**EL PASO COUNTY**

## **COMMUNITY SERVICES DEPARTMENT**

**Subject: Forest Lakes Phase II PUD Development Plan/Preliminary Plan, Review #4  
(PUDSP-18-001)**

SHEET NUMBER  
 10 OF 16  
 PUDSP-18-001

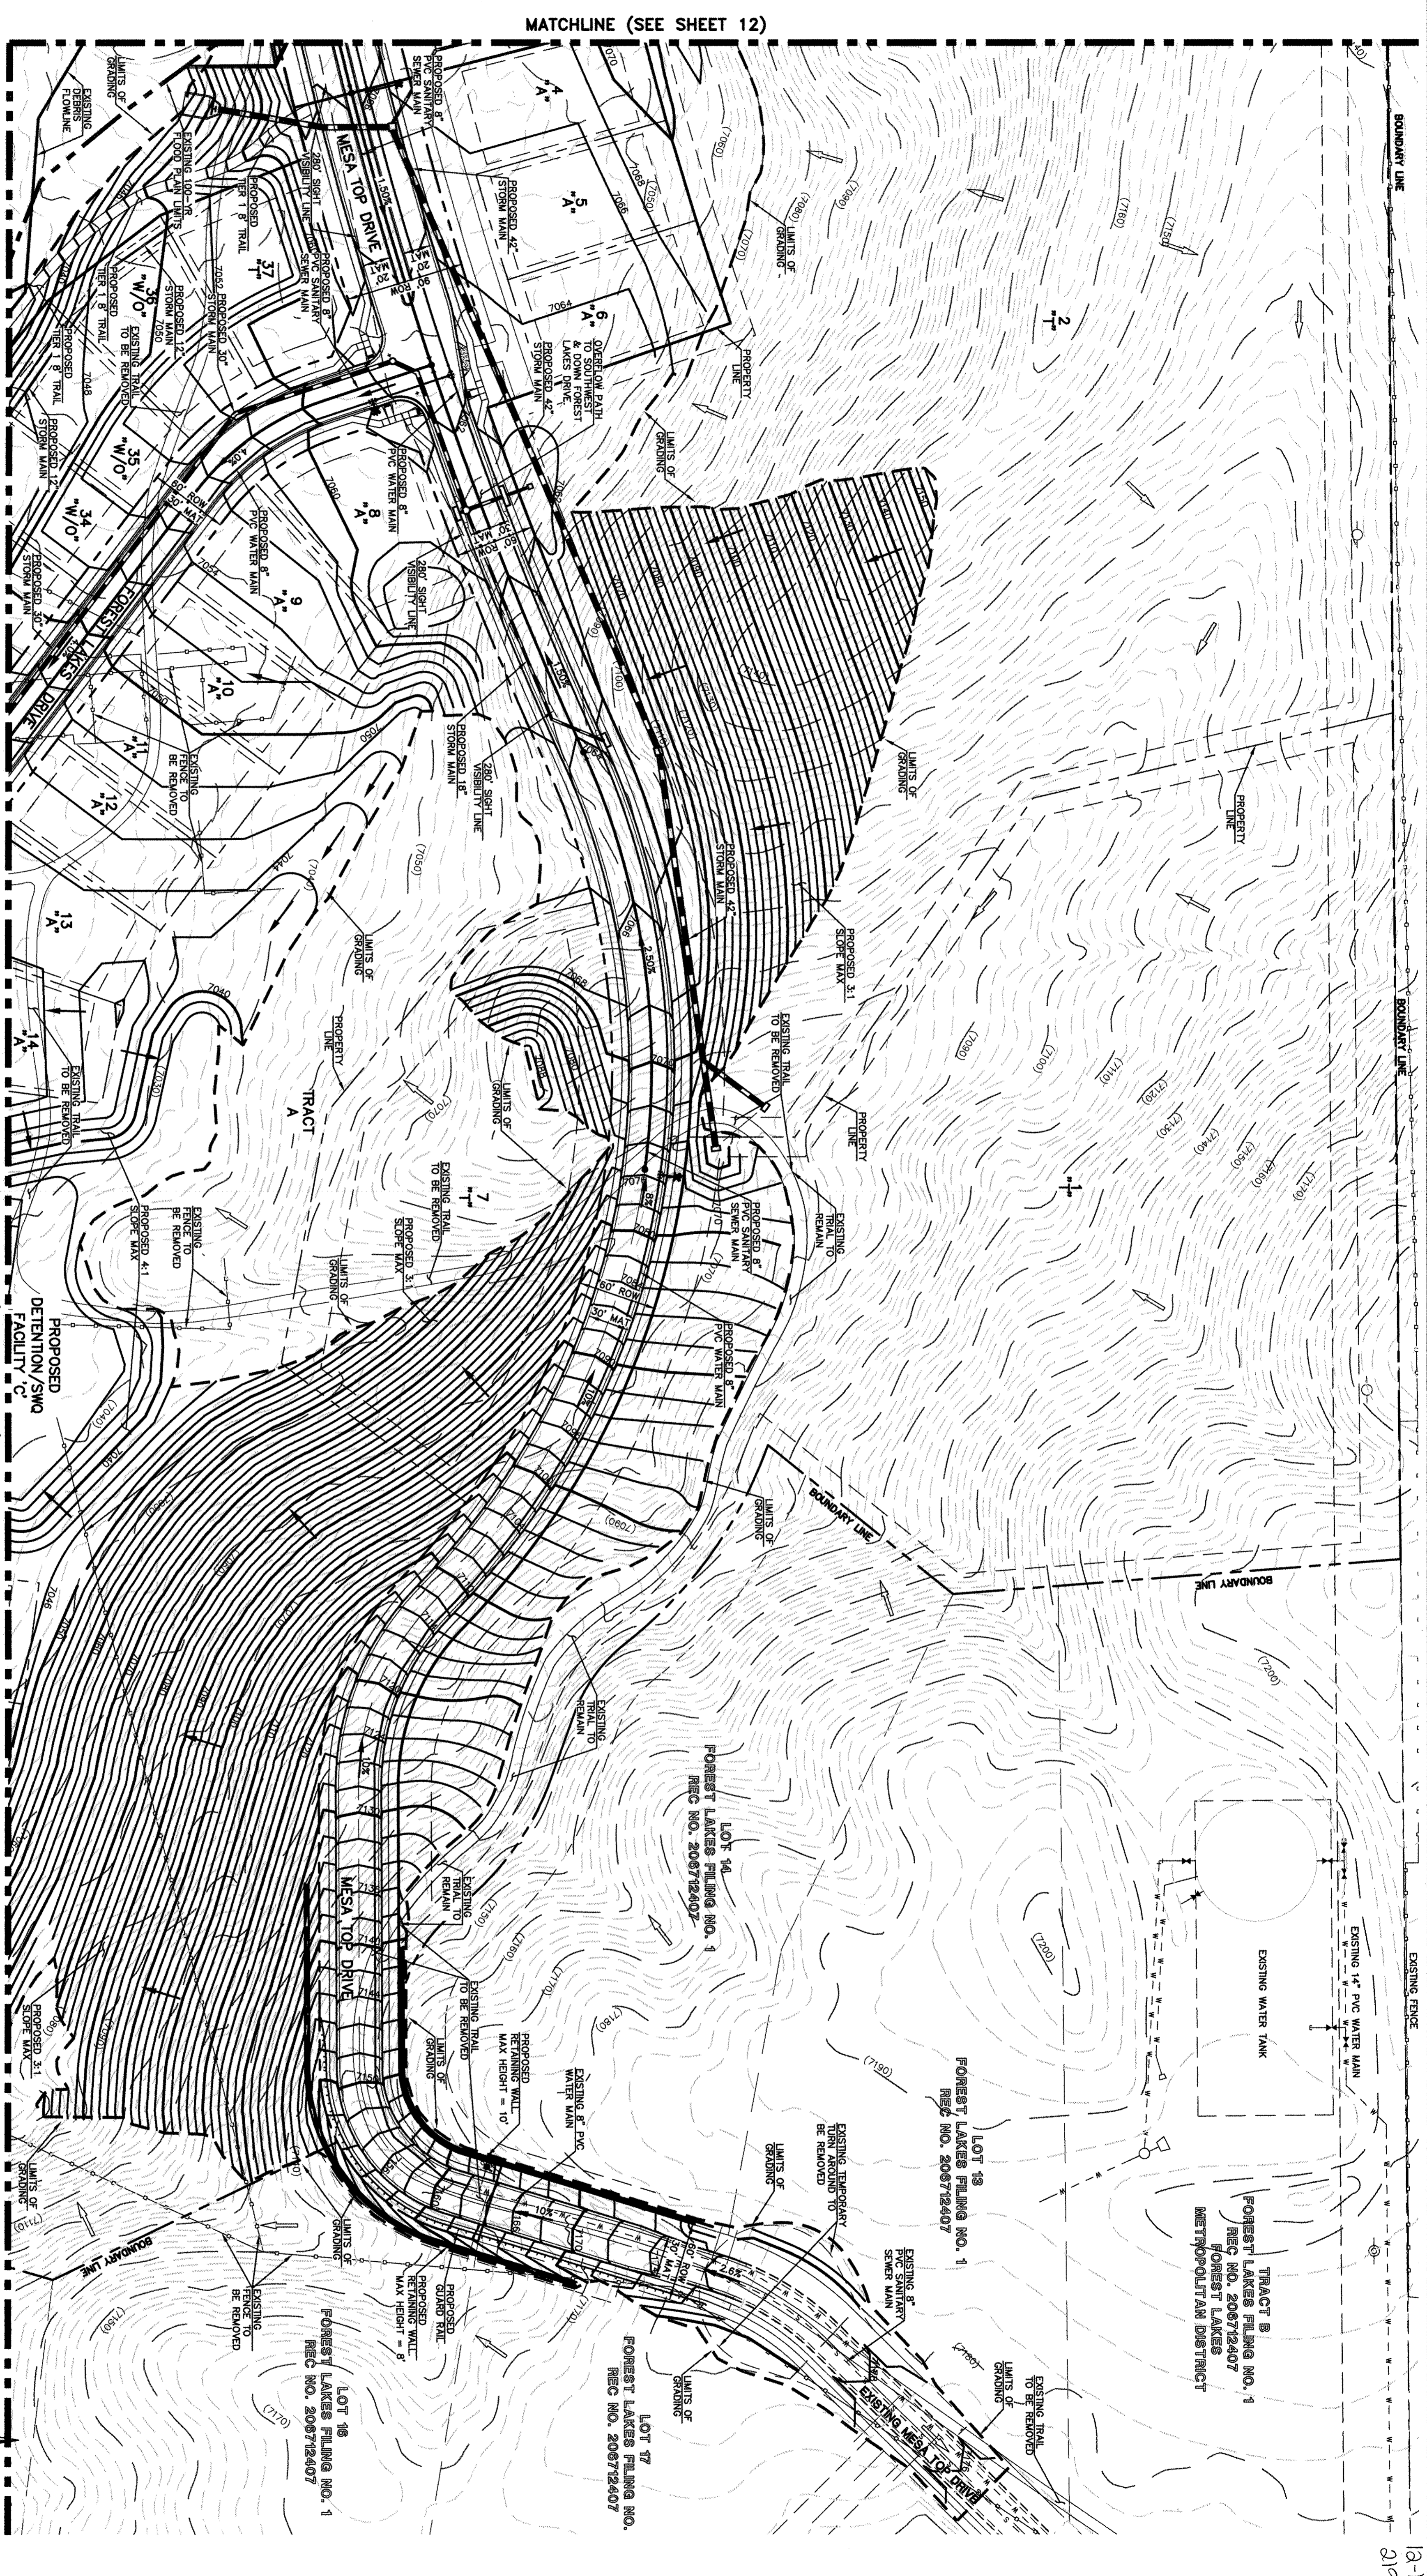
Parks staff continues to acknowledge and appreciate the modifications to the Forest Lakes Secondary Regional Trail and the adjacent emergency access road. The plans and details follow the mutually agreed-upon configuration and trail specifications, as shown on Sheet 10 / Details of the PUD Preliminary Plan Amendment.
